EAST PRESTON PARISH COUNCIL

19th December 2018

Re: EP/166/18/HH – 100 Sea Road, East Preston, BN16 1NP

PROPOSED FLOOR PLANS 1:50

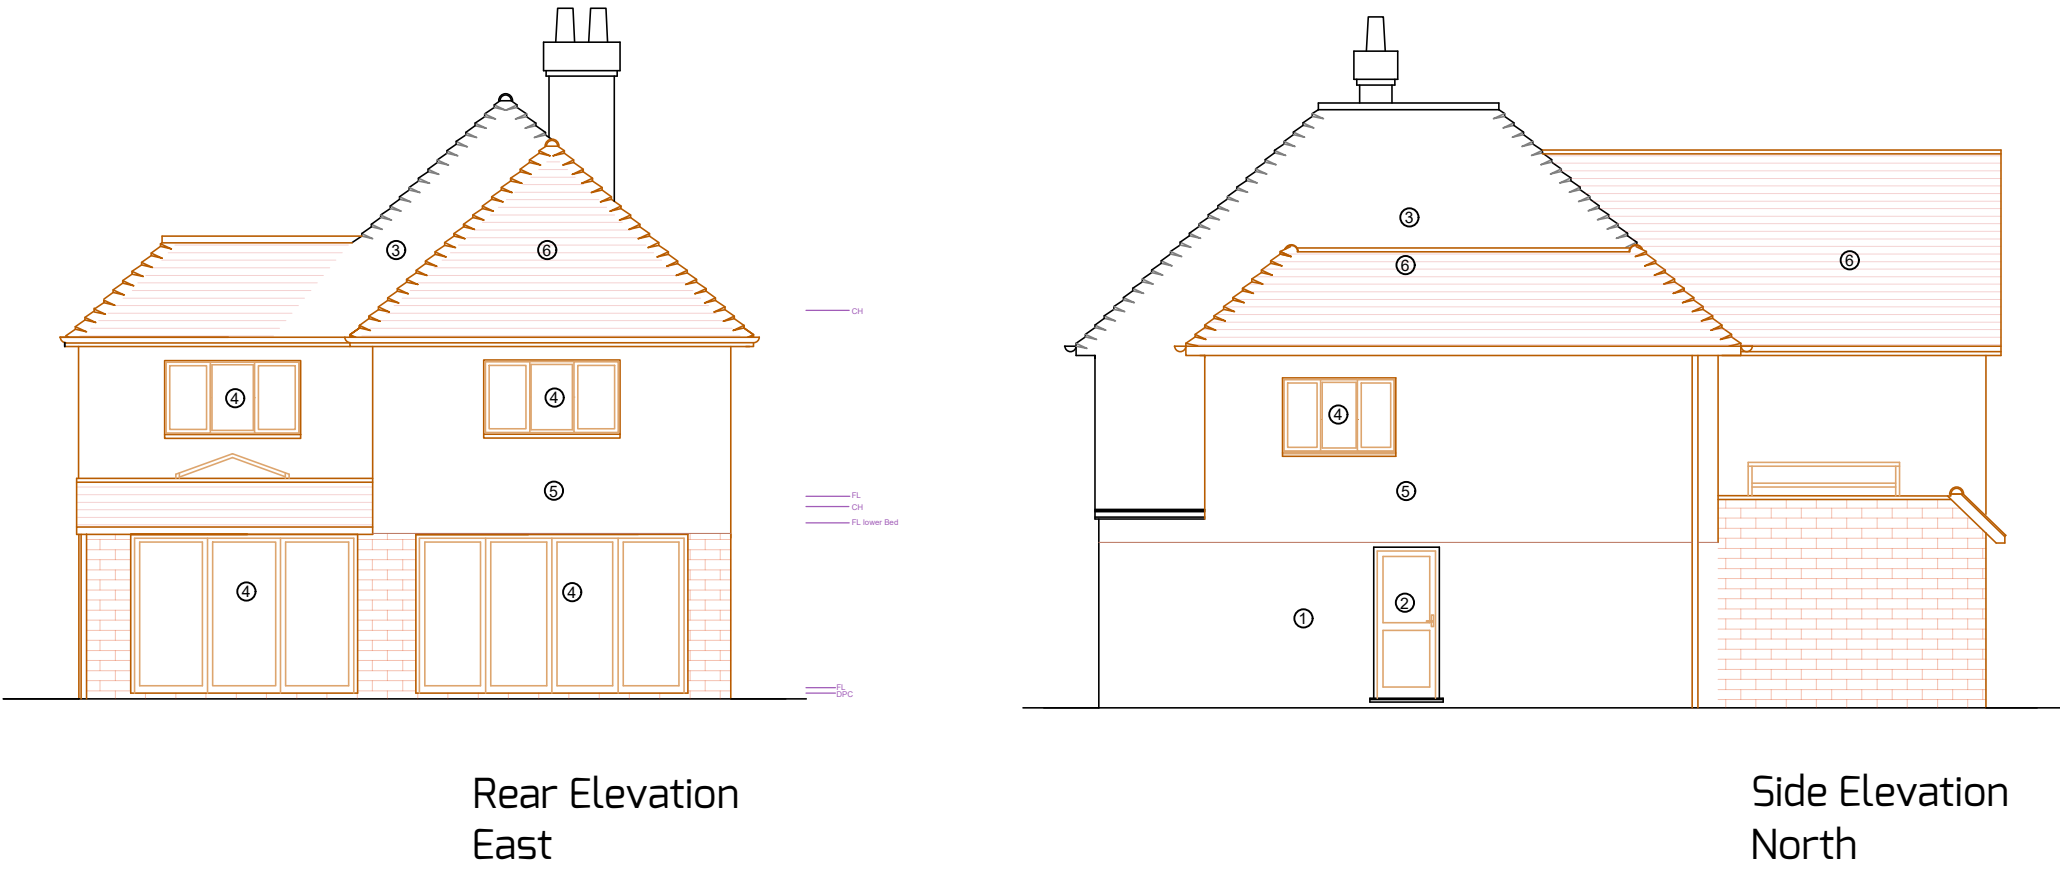
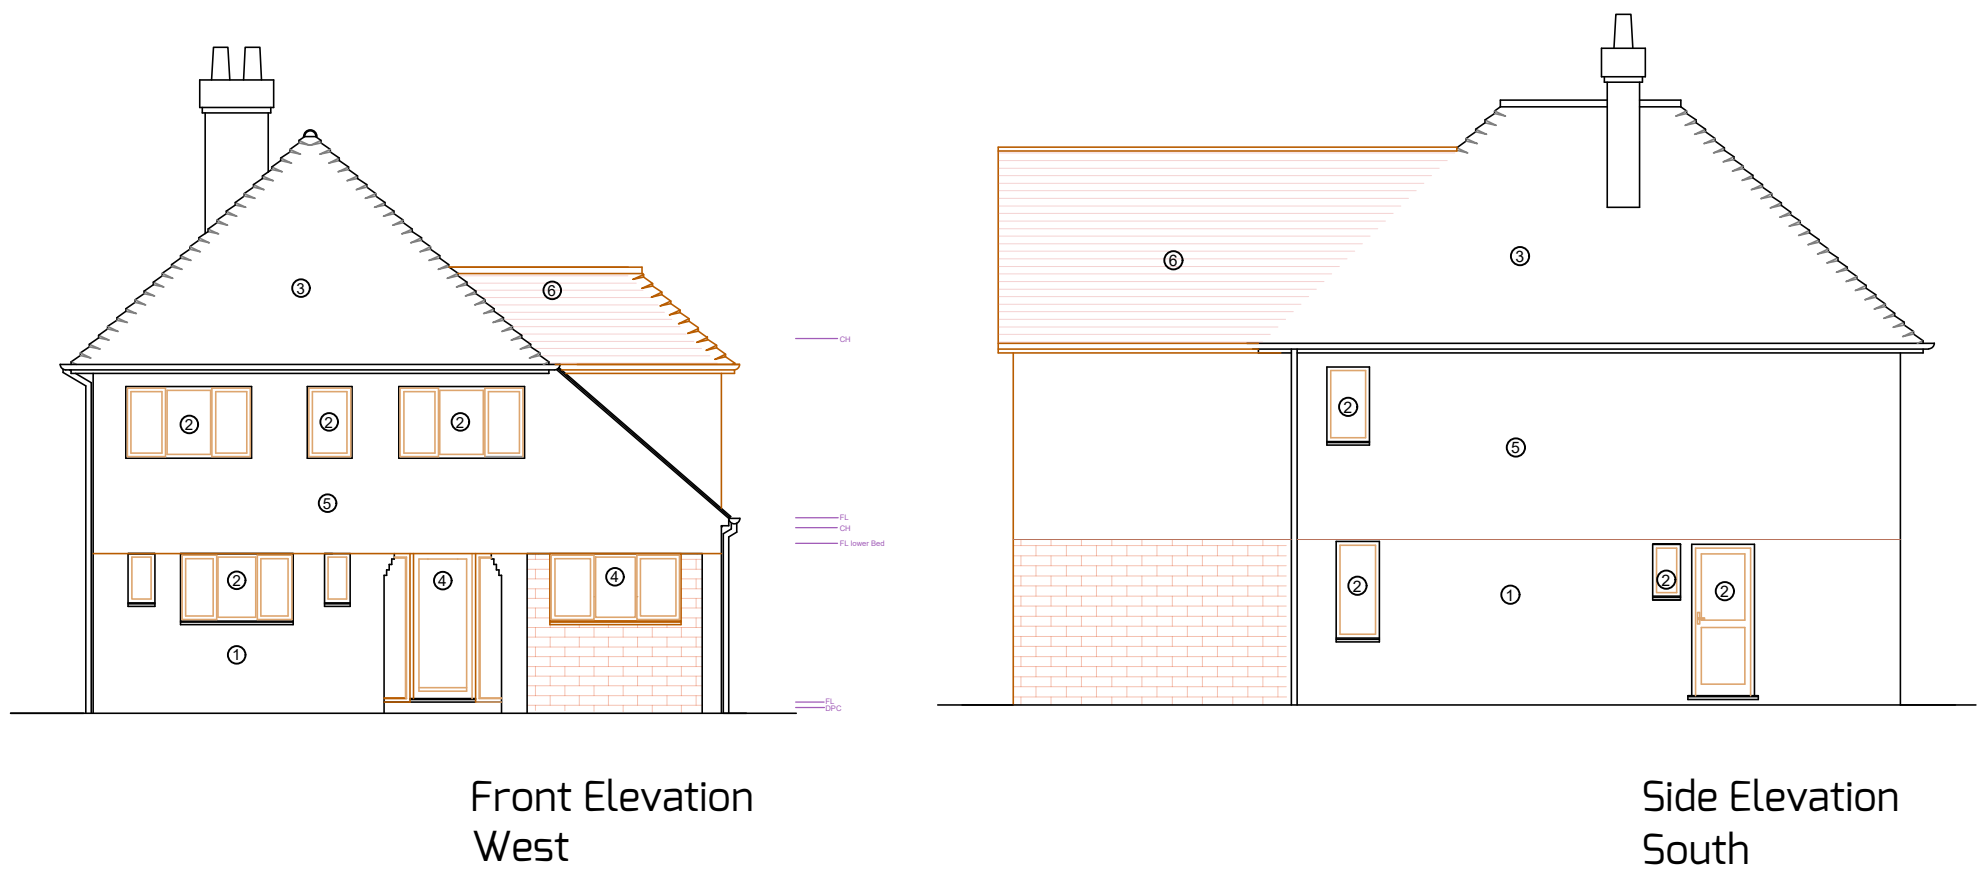
The proposed two-storey extension will be unneighbourly and overbearing both to properties in Sea Road but more importantly, to properties in Normandy Lane, to the west of the development site, as these are all bungalows. The two-storey extension will bring the two-storey part of the building much closer to the boundary with the properties in Normandy Lane, two of which share a boundary with 100 Sea Road. We believe the two-storey extension is contrary to Policy D DM1 of the Arun Local Plan, part 3, which states development should "[h]ave minimal impact to users and occupiers of nearby property and land. For example, by avoiding significant loss of sunlight, privacy and outlook". The proposal may also be contrary to Policy D DM4 of the Arun Local Plan which specifically concerns extensions to existing properties. Section c. of the policy states "the extension or alteration [should] not have an adverse overshadowing, overlooking or overbearing effect on neighbourhood properties" – as stated above, this council feels neighbouring properties in Normandy Lane and Sea Road will be adversely affected.

This Application proposes to lose the existing decorative leaded lighting of the front windows, the decorative, feature brickwork between the upper floor windows, the attractive brickwork above the ground floor windows, the wooden beam above the front door and to render over the exposed timbers on the front elevation. These are all attractive and distinctive features of the existing property and its neighbours. We believe the removal of these design features is contrary to Policy D DM1 of the Arun Local Plan as the proposal does not “make the best possible use of [...] building materials [...] and design features” and would result in a bland, featureless elevation, totally out of character with neighbouring properties. Removal of these features is also contrary to Policy 1 of the made East Preston Neighbourhood Plan as these alterations do not “reflect and enhance the architectural and historic character [...] of the surrounding building”. Policy 2 of the Neighbourhood Plan also states, “alterations to existing buildings, will: preserve the street scene”. Drawing 18075/02R2 states in the Elevations key, “5 – New rendered wall to match existing”, but there is no existing rendered wall on the front elevation to be matched with – side elevation yes, front elevation no.

Although not easy to read on the drawings, it is possible the two-storey extension is less than 1m from the boundary with no. 102; this would be contrary to Policy D DM4 of the Arun Local Plan, specifically Section d, “[...] any extension or alteration at first floor level does not come to within a minimum of one metre of the side boundary.”

The existing dormer on the northern elevation of the property will be lost but matches with the dormers on the two properties immediately to the north of this property. This will have an unacceptable impact on the host property and unacceptable negative impact upon the uniform character and appearance of neighbouring properties in conflict with Policies D DM1 and D DM4 of the Arun Local Plan and the National Planning Policy Framework.
